Date: 23-Dec-2025
Our Ref: 2025/93191

**Non material amendment to previous permission 2024/92035 for demolition of
existing conservatory, rear lean to and chimney and erection of single storey rear
extension and raised patio
15, Lincroft Avenue, Dalton, Huddersfield, HD5 8DS
Application Number: 2025/93191**

Client	Mr Mahmud		
Address	15 Lincroft Avenue Huddersfield		
Title	Proposed Ground Floor Plan		
Drawn By	DK	Date	July 2024
Check By		Scale	1:50
Sheet No.	2024 / 461 / 04

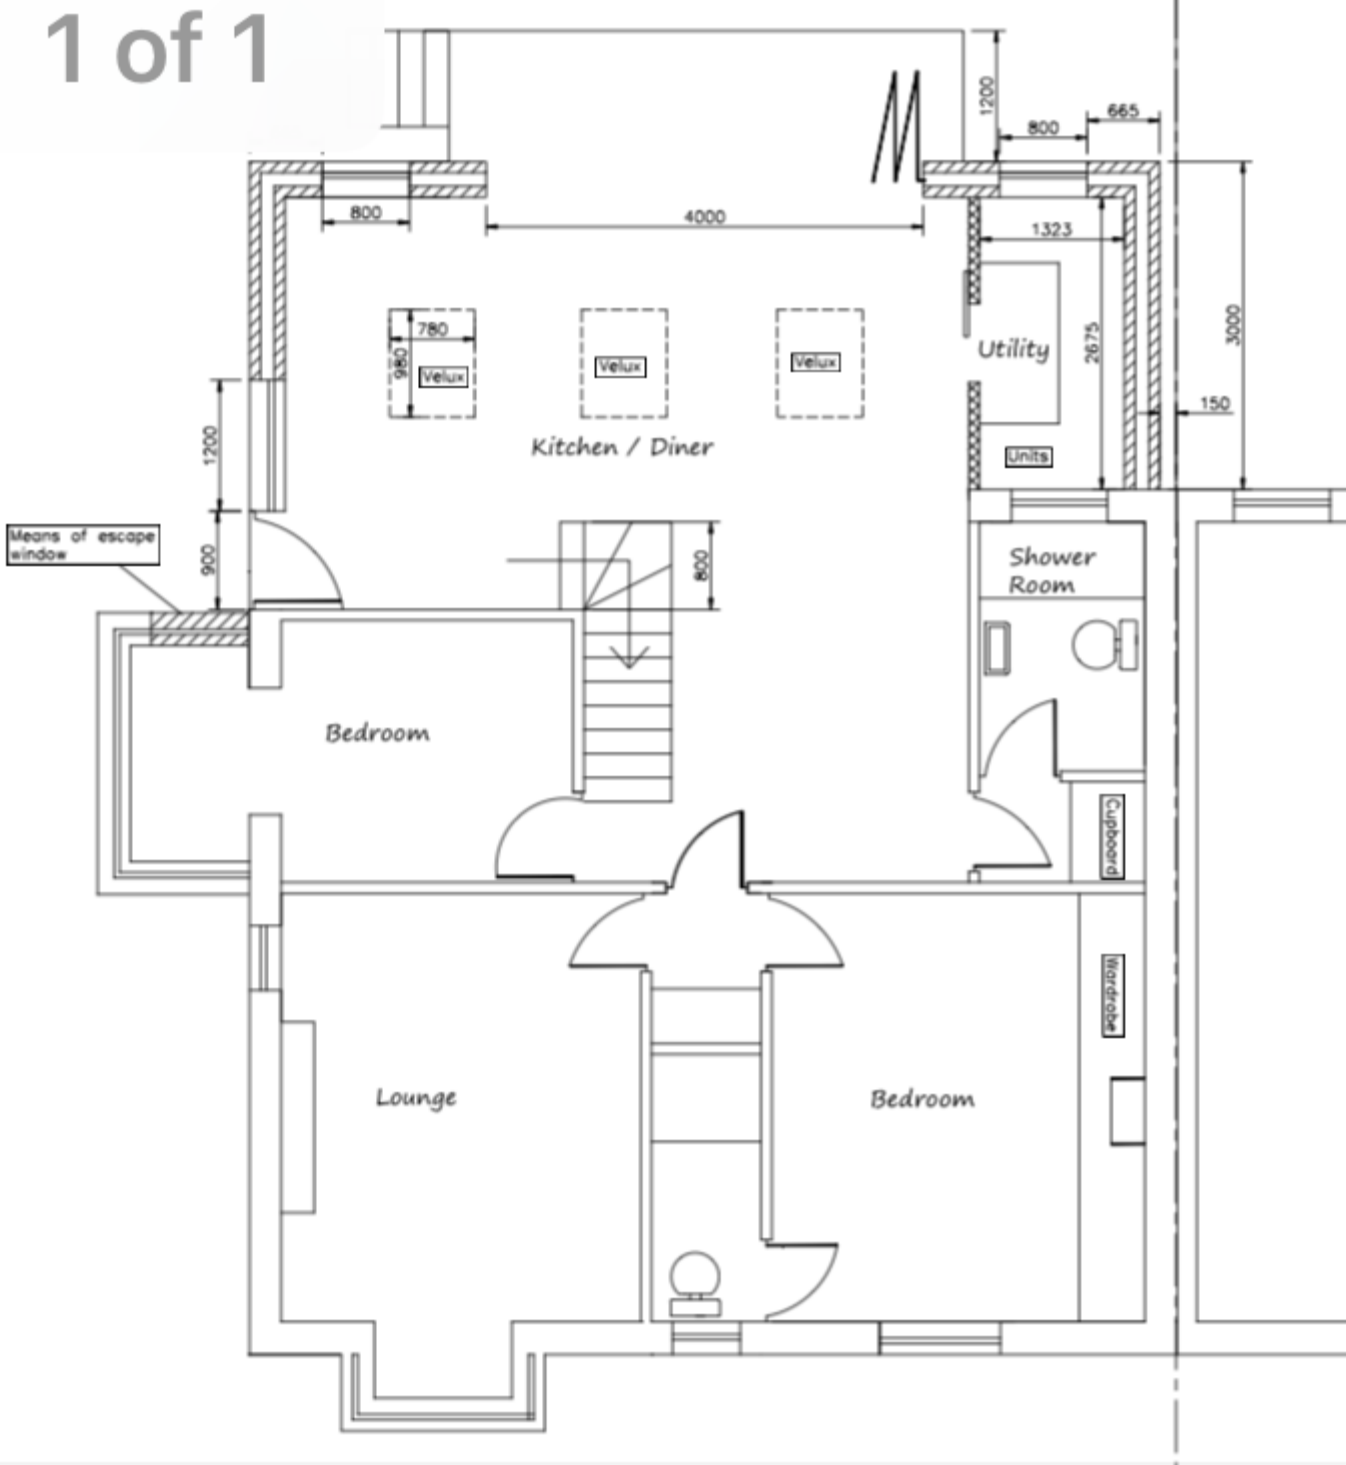
The amendment is shown on drawing no's. 'Proposed Ground Floor Plan 2024 / 461 / 04'
and 'Proposed Site Plan 2024 / 461 / 06' and shows an increase in the size of the
rooflights.

I confirm that the alterations are acceptable and may be considered as a non-material
amendment to the approved drawings. It should be noted that this letter relates only to the
non-material amendment sought and it is not a re-issue of the original planning
permission. The two documents should be read together and as such, all conditions
imposed on the original granting of planning permission apply to the proposal as now
amended. A copy of this letter and the amended plans will be retained on the public record
of approved documents.
